Your ref:
Our ref: 23/01864/RM
Please ask for: Valera Lvov
Direct dial: 01553 616865
E-mail: borough.planning@west-norfolk.gov.uk

Details: **RESERVED MATTERS APPLICATION; Construction of 3no Dwellings. at Towler Coaches Ltd 24 Church Road Emneth Wisbech Norfolk**

I have received a planning application as detailed above but cannot process it until I receive some more information:

SCALE	AS SHOWN AT A1
DATE	JULY 2023
DRAWN	STB
DRAWING NO	292 - 01

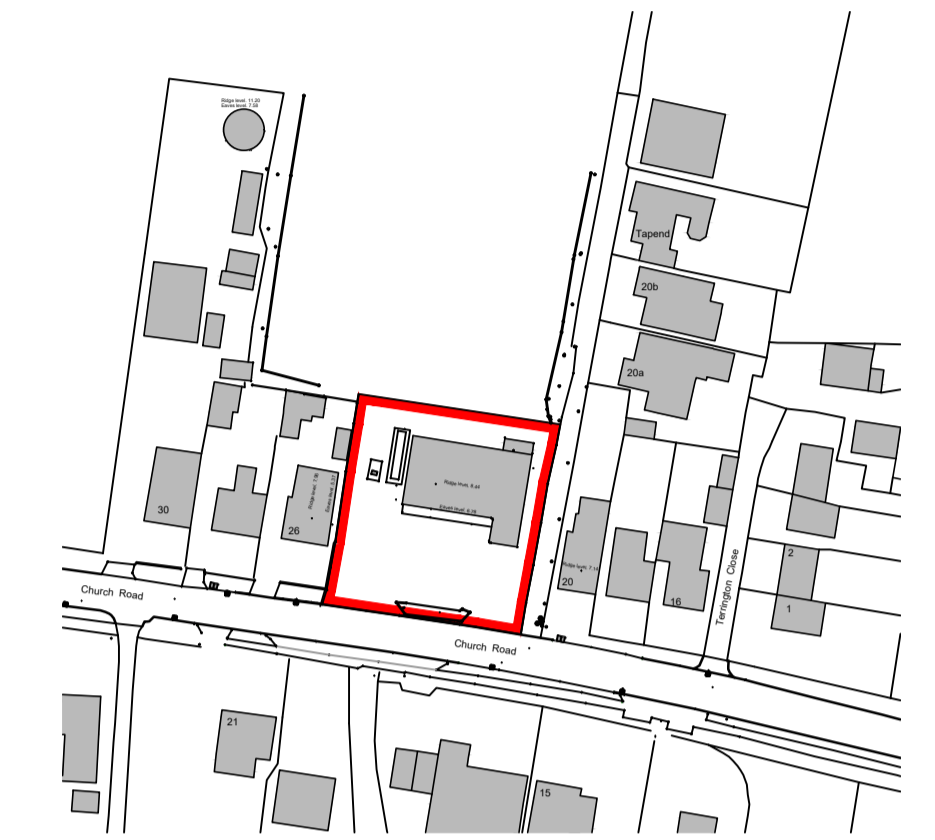
1. Please check the location plan and the red line provided on Drawing 292 - 01 as that does not match the Location plan on the Outline application.
2. The Community Infrastructure Levy was adopted by the Council on 19 January 2017 and came into force on Wednesday 15 February 2017.
